SUPPLEMENTAL/AMENDED INFORMATION
TO DRAINAGE REPORT
DATED APRIL 23, 2013

INLAND KENWORTH
Fortuna Rd West of 76th Street NW

RESPONSES OF CITY OF ALBUQUERQUE COMMENTS:

**Re: Inland Kenworth, Fortuna Road, Drainage Report and Conceptual Grading
and Drainage Plan**

\\MPC\PROJECTS\1900-1\1998\1941\1941\1941 CAD FILES\dwg\1941 CG-103 AS-BUILT.dwg, 7/14/2014 2:54:09 PM, thcr

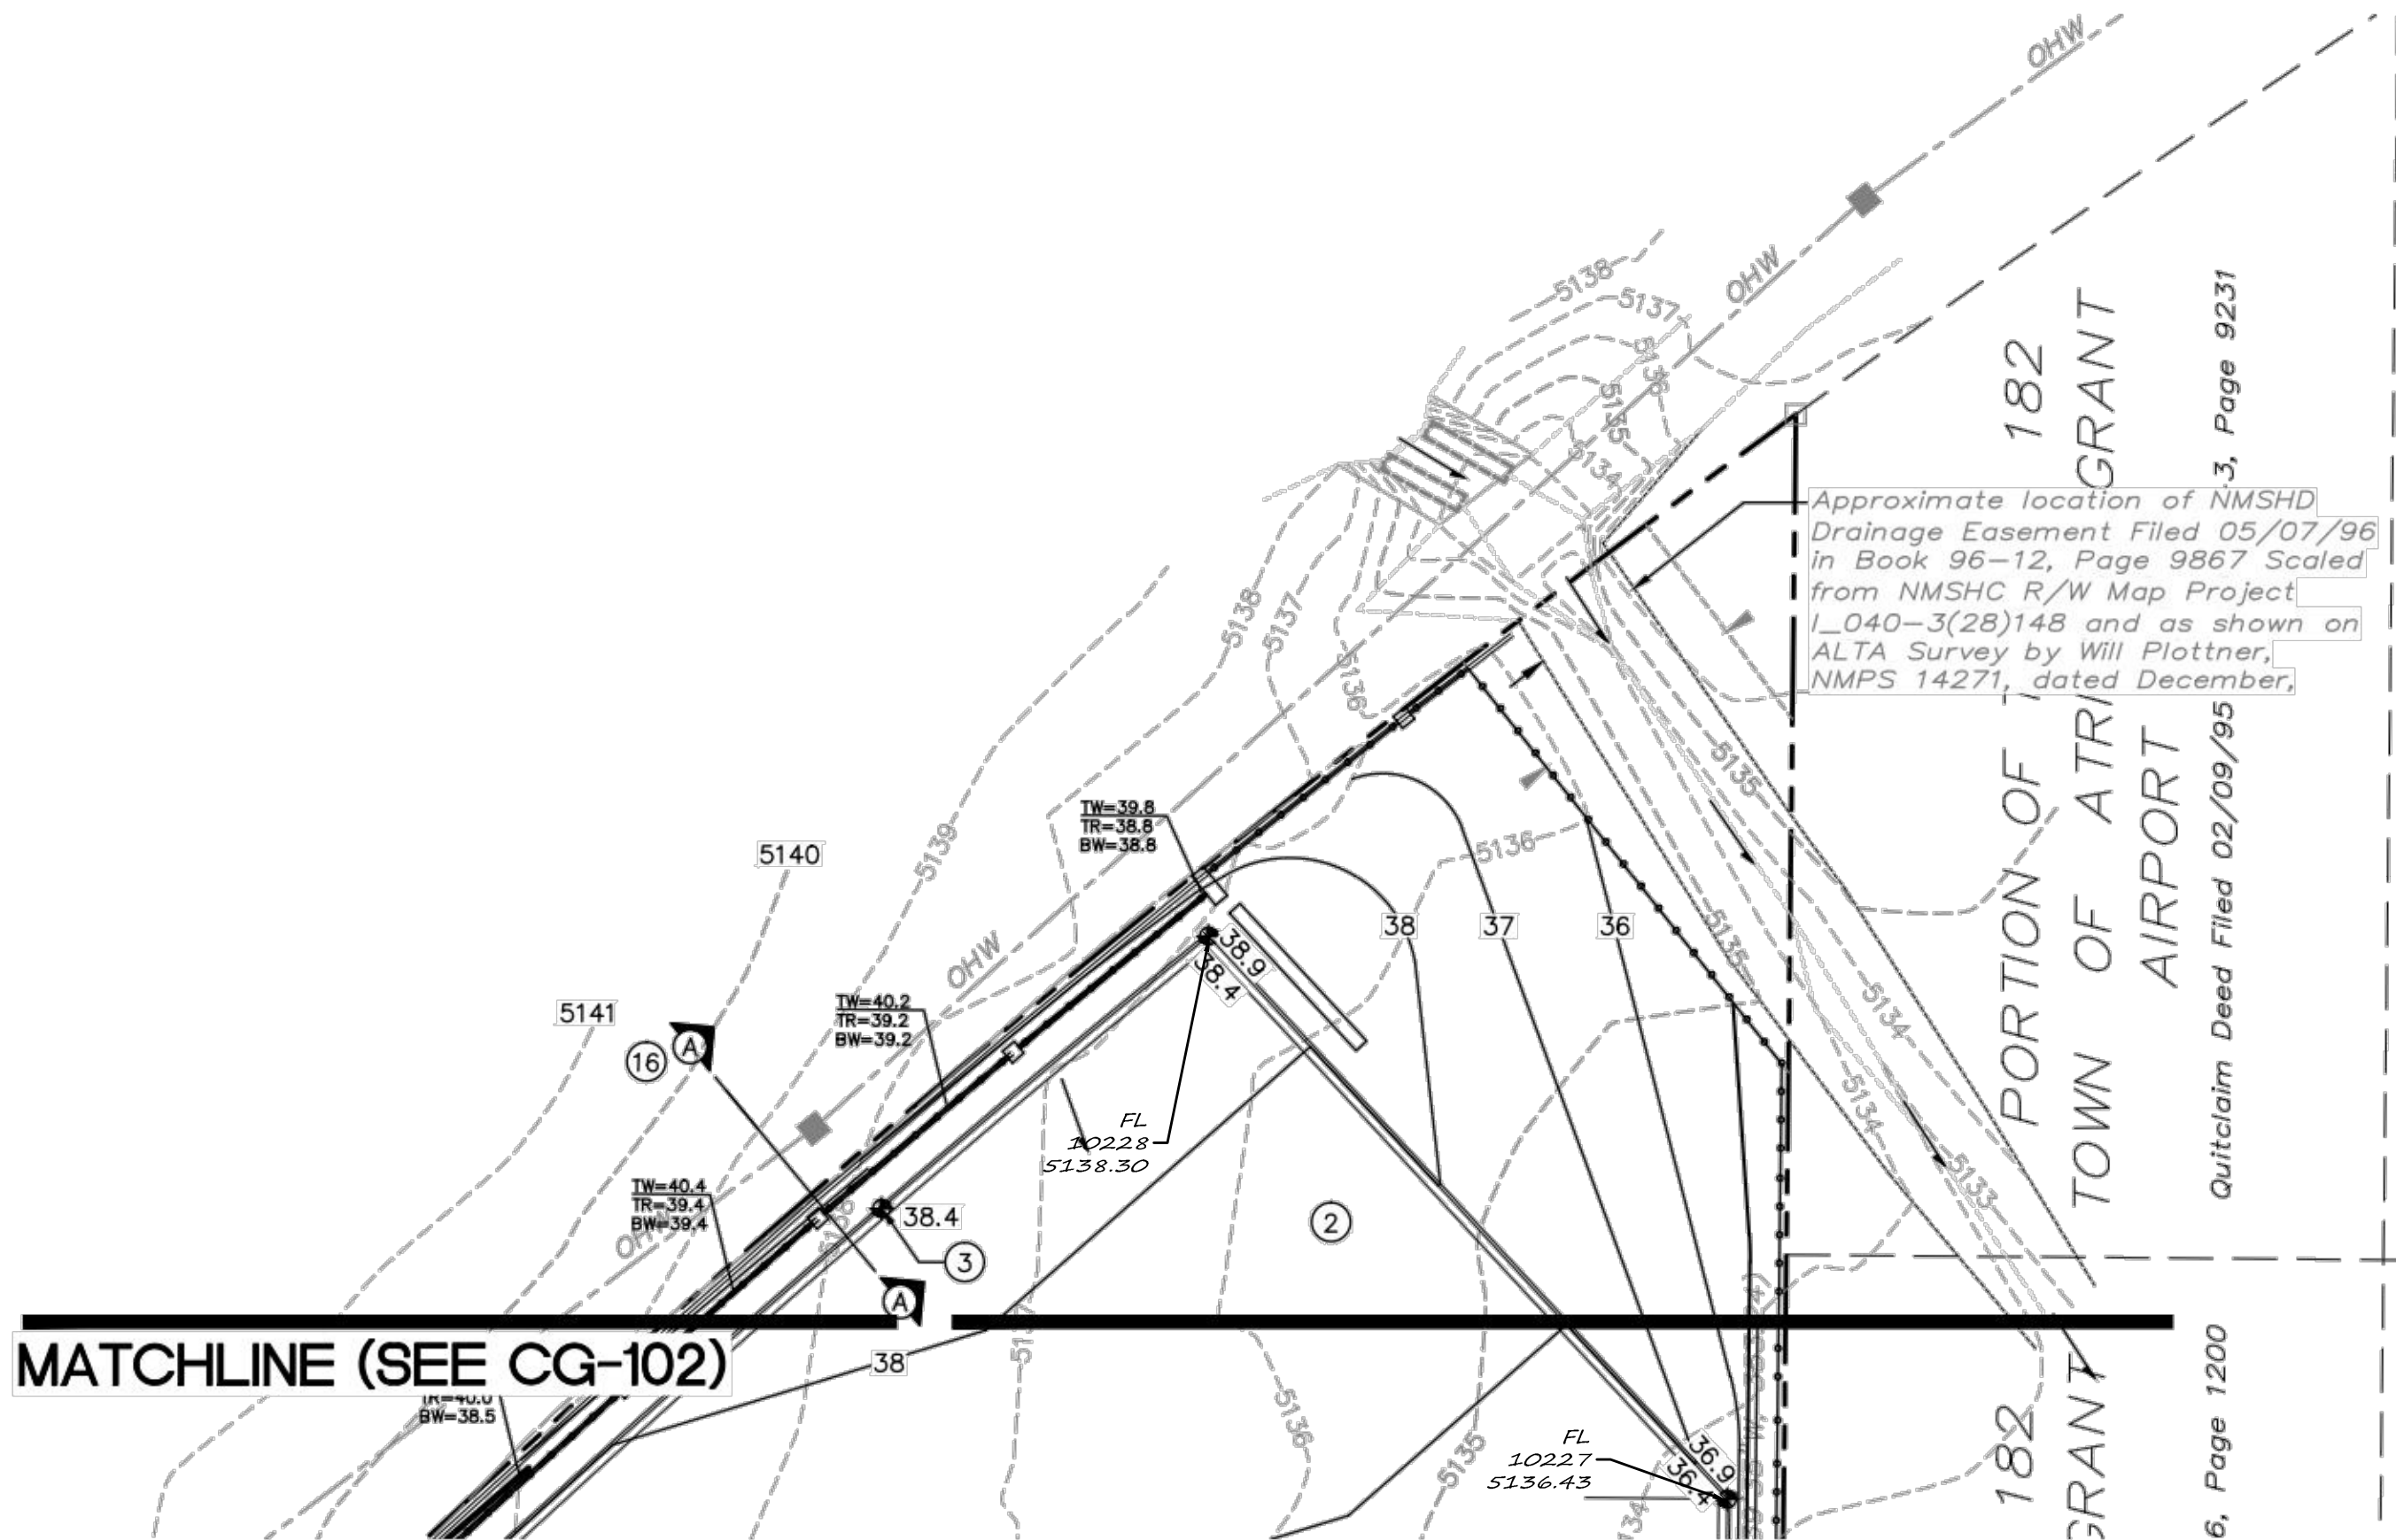
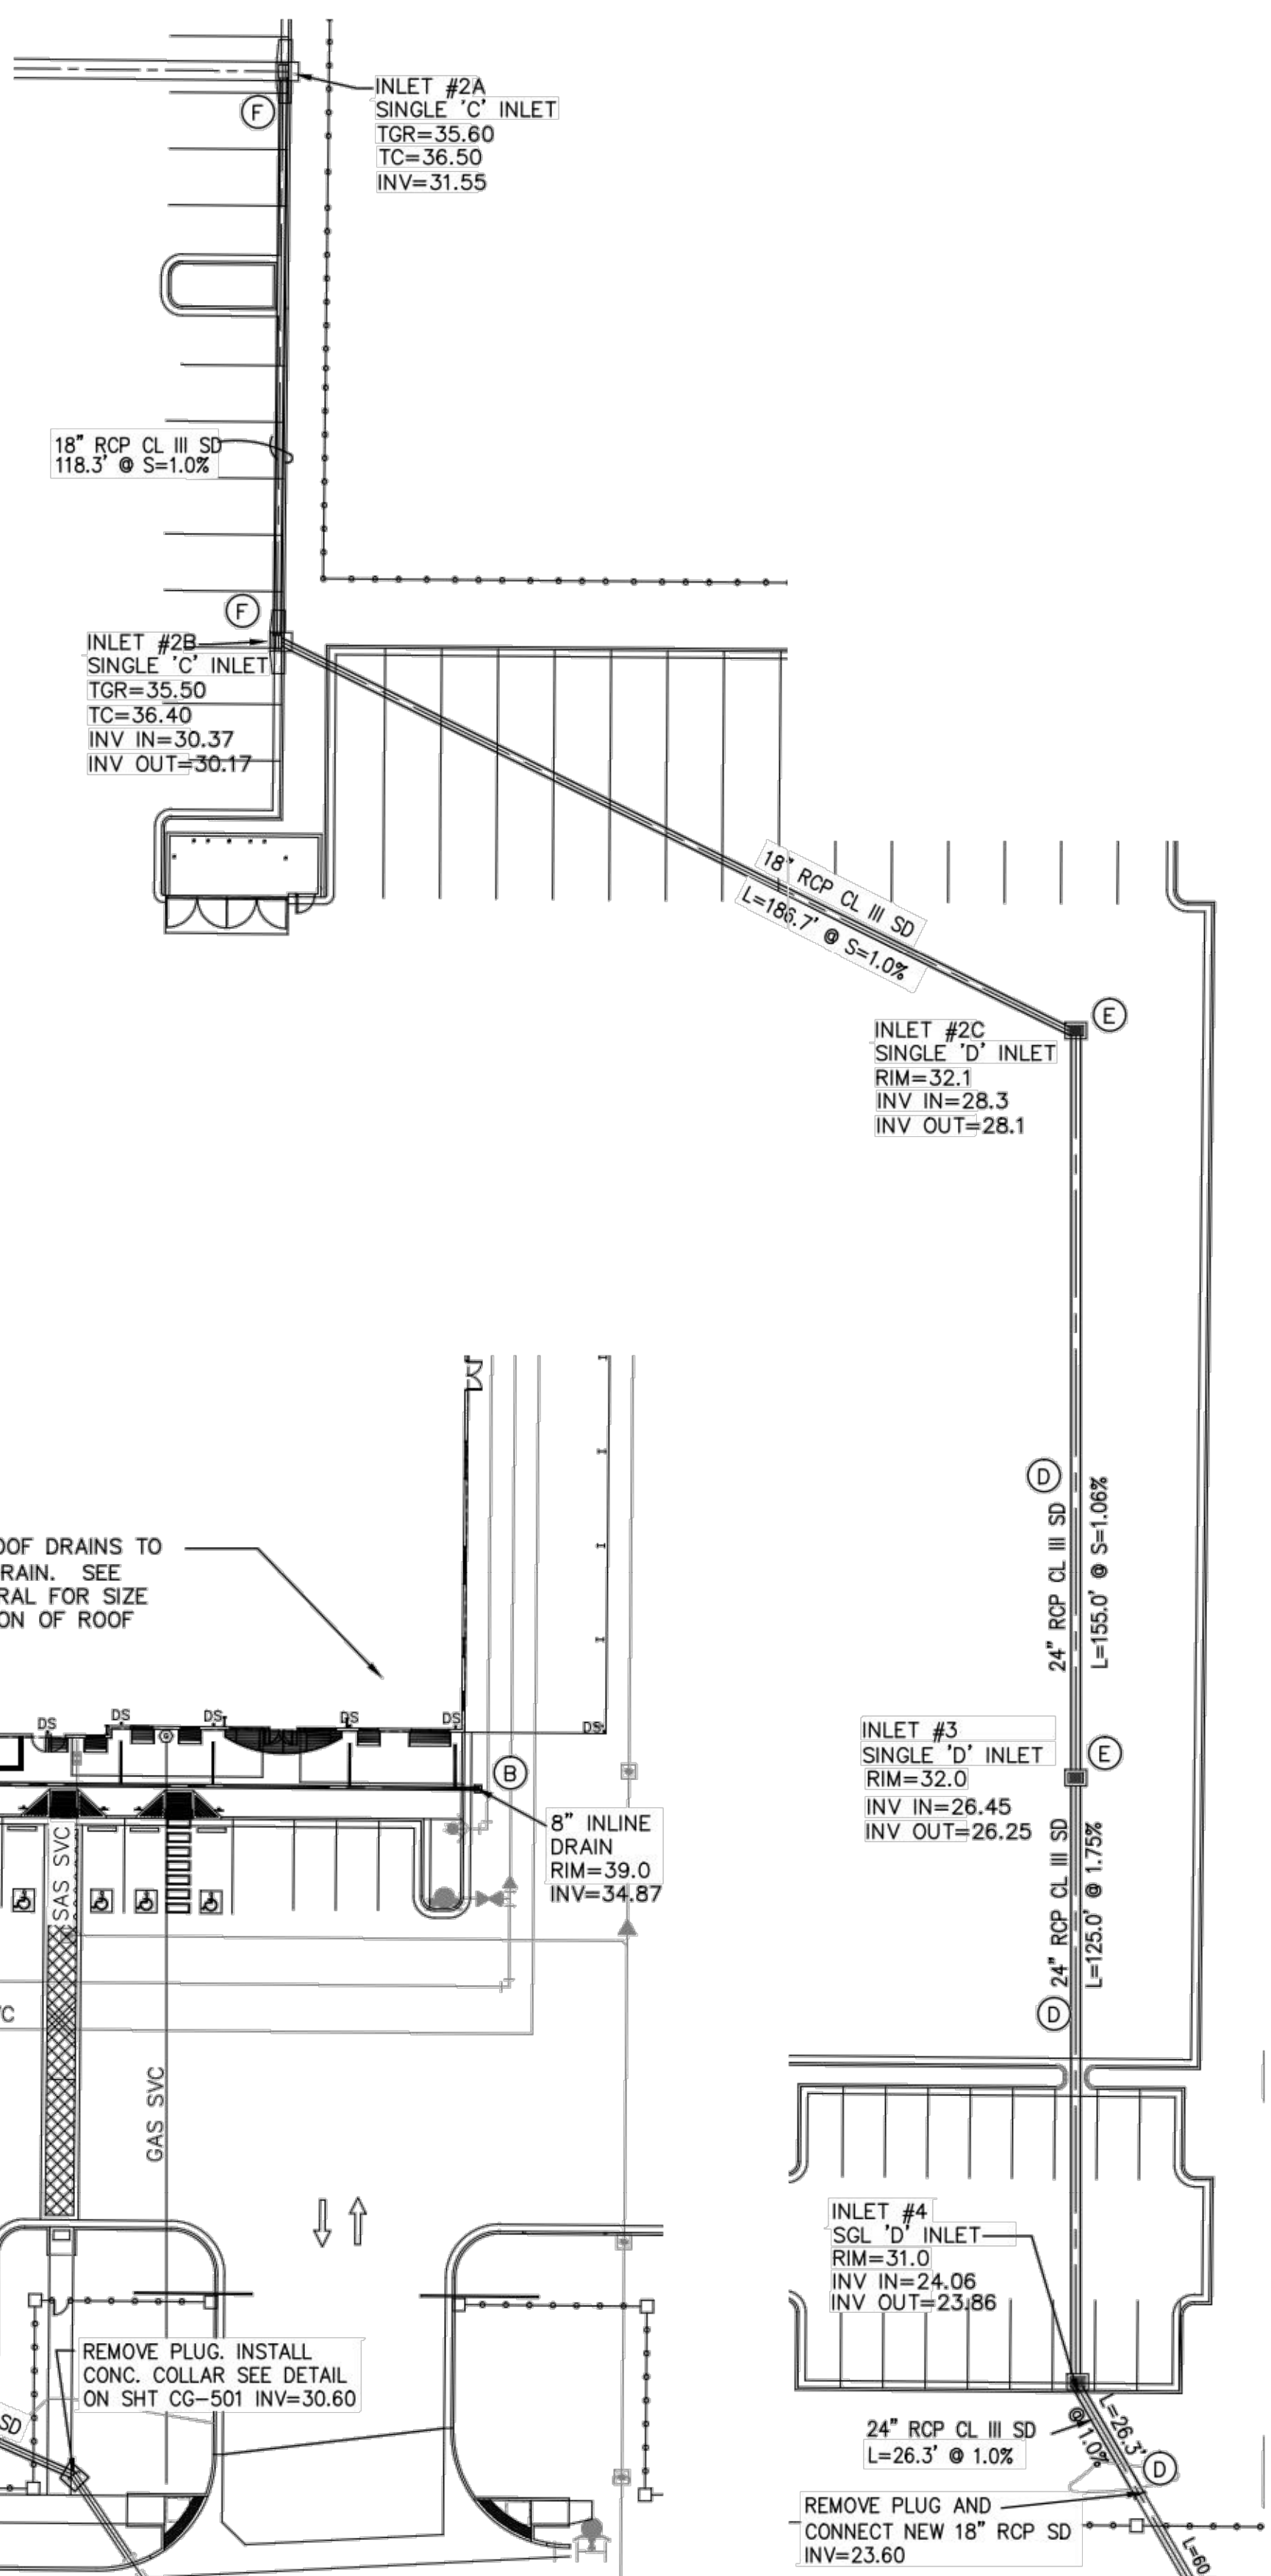
1. Per the DPM, p. 22-106, where the peak flow in the proposed lateral exceeds 10 percent of the main line, the angle of confluence should not exceed 30 degrees. This can be worked out at DRC.

- 1) Two sheets are numbered CG-101.
- 2) Please include proposed flow lines and back of sidewalk elevations along Fortuna Rd.
- 3) Provide inlet capacity calculations. Assume 50% clogging factor in your calculations.
- 4) Add all the curb opening sizes on the plans.
- 5) Provide calculations for the channel located east side of Basin 2. Include a section for the channel on the plan. Can the runoff overflow the channel when making a 90 degree turn?
- 6) Add all the storm drain pipe sizes to the plan.
- 7) The runoff appears to be block at the north east corner of the property where the offsite runoff enters the site.
- 8) Based on the documents provided the allowable discharge is 3.76 cfs/ac. Therefore, the total discharge is (8.86 ac x 3.76 cfs/ac) 33.31 cfs, and the plan shows an allowable discharge of 34.60 cfs. Please clarify.

1. The storm drain has been revised to provide a max. 30 degree angle of confluence—see attached grading plan and storm drain calculations.
2. Capacity calculations for inlets are included.
3. Channel has been eliminated and replaced with 2- Type C inlets and storm drain.
4. Channel has been eliminated.

- 6) Storm drain sizes have been added to the plan—see sheet CG-103 for details.
- 7) There is a small stilling basin at the outlet of the culverts at the northwest corner of the site. Inverts of the culverts are 33.4 and 33.6, and storm water will overflow to the drainage swale in the NMDOT easement at an elevation of 34.
- 8) Drainage calculations on grading plan were incorrect. Calculations included in approved drainage report dated April 23, 2013 are correct showing 32.2 cfs discharging from site which is less than the 33.3 cfs allowable.
